Address: 22 Park Lodge View Huddersfield HD8 9UN

Application number: 2022/91702	
What is the application for?:	Removal of existing conservatory and erection of single storey rear extension
Address of the site or building:	24, Park Lodge View, Skelmanthorpe, Huddersfield, HD8 9UN
Postcode:	HD8 9UN

EXISTING SITE PLAN
SCALE 1:200

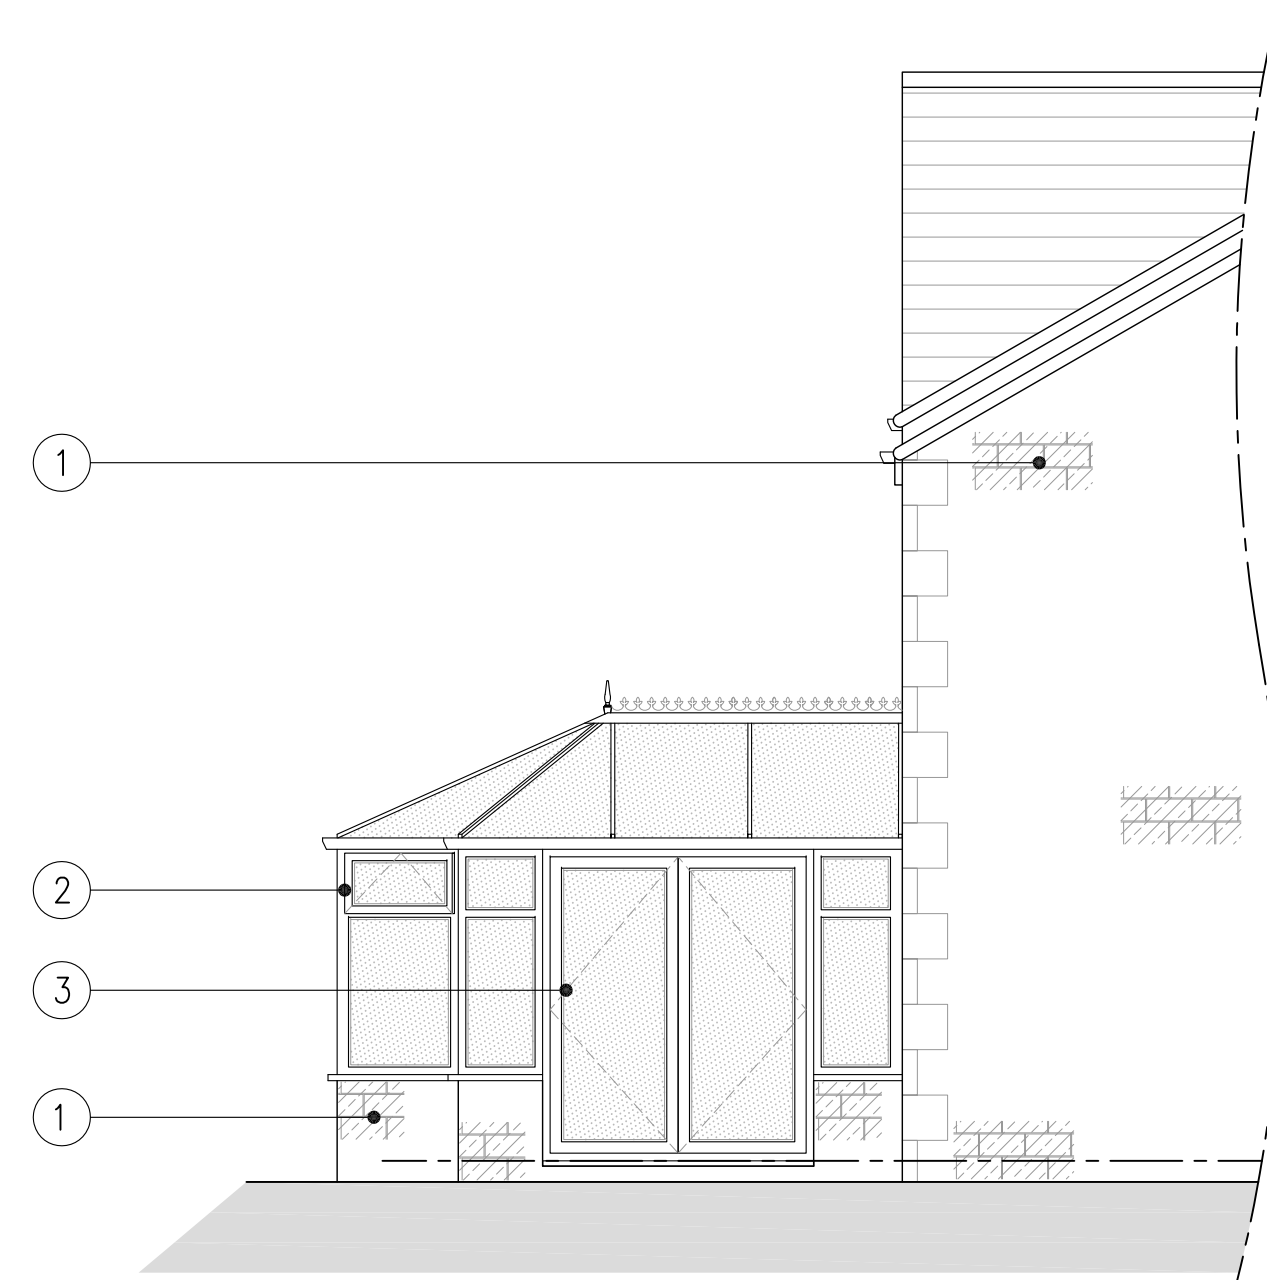
Type of comment: A general comment	
Do you wish your comments to be published on the website anonymously?	No
<p>The site plans submitted with this application are incorrect and indicate that ownership of the portion of Cul De Sac in front of No 24 is by Mr and Mrs Crossland. They have a wayleave over this portion of the access. We can produce documents to confirm this. We have no OBJECTION to the proposed building works forming the application. Although we do have concerns related to access to our property during the works.</p>
